# Rezoning Transportation Analysis

Petition Number: 2023-147

Date	Description
12-27-23	First Review (IW)
01-24-24	Second Review (IW)

Rezoning Plan
 Charlotte NC 28212

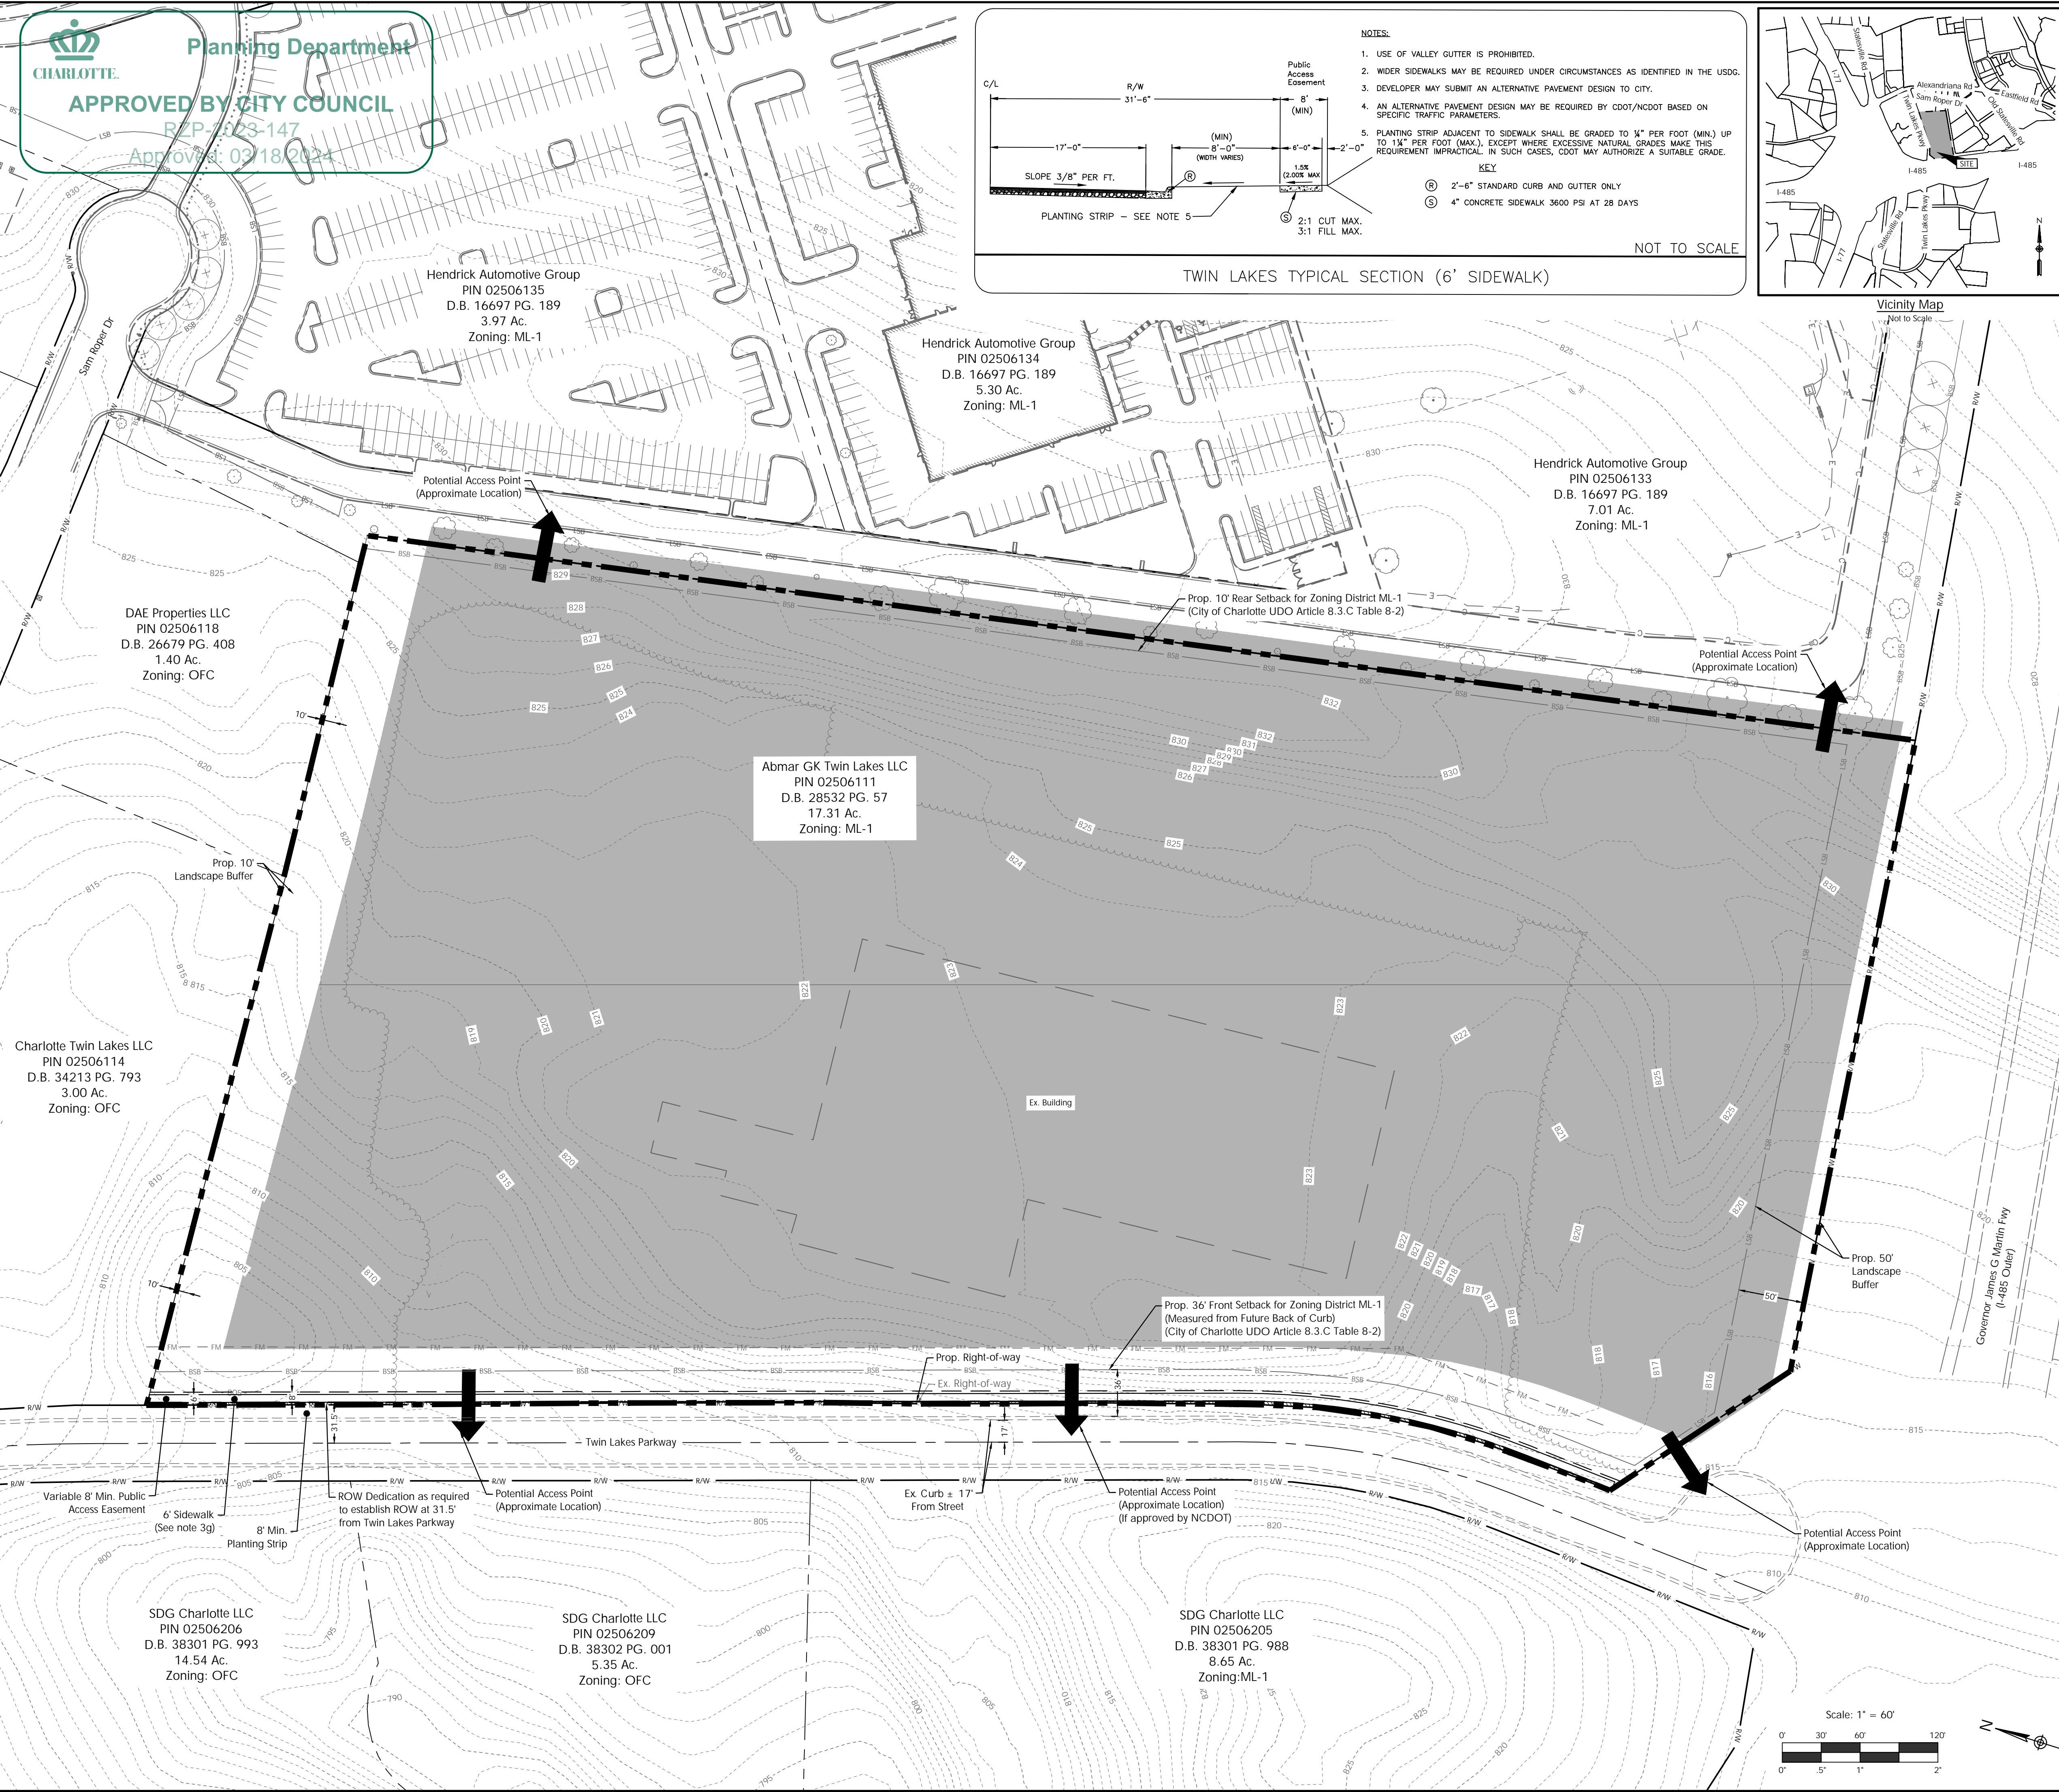
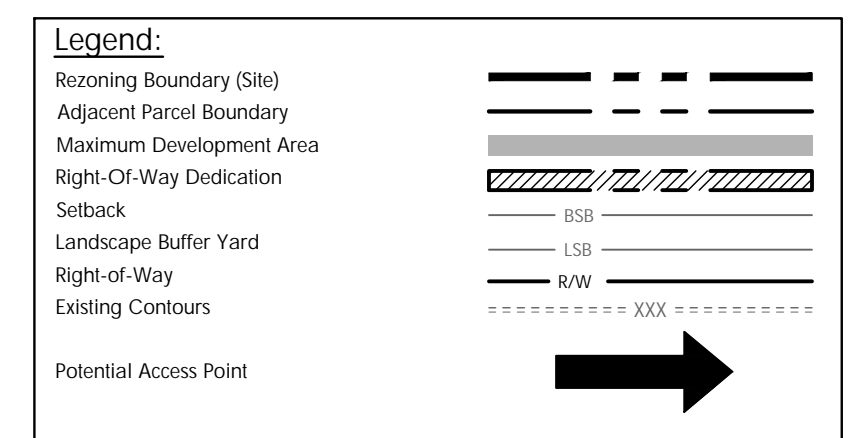
**a. ~~Twin Lakes Parkway:~~** Location of future curb and gutter is to be 17 feet from centerline.

~~Label and dimension the curb and gutter from the centerline for each road on the site plan.~~

**3. New Comment 1.25.24:** Add density and land use information to the site plan.

**4. ~~Revise site plan and conditional note(s) to commit to dedicate 31.5 feet of right-of-way from the Twin Lakes Parkway road centerline. The site plan shall label and dimension the right-of-way from the road centerline.~~**

- ~~9. Revise site plan and conditional note(s) to construct 8-foot planting strips and 6-foot sidewalks on Twin Lakes Parkway. The site plan shall label and dimension both items from the back of curb and gutter or edge of pavement. Add conditional note The entire facility must be outside of the right of way and within a public access easement. Add conditional note committing to construction and maintenance of the 6-foot sidewalks on Twin Lakes Parkway.~~
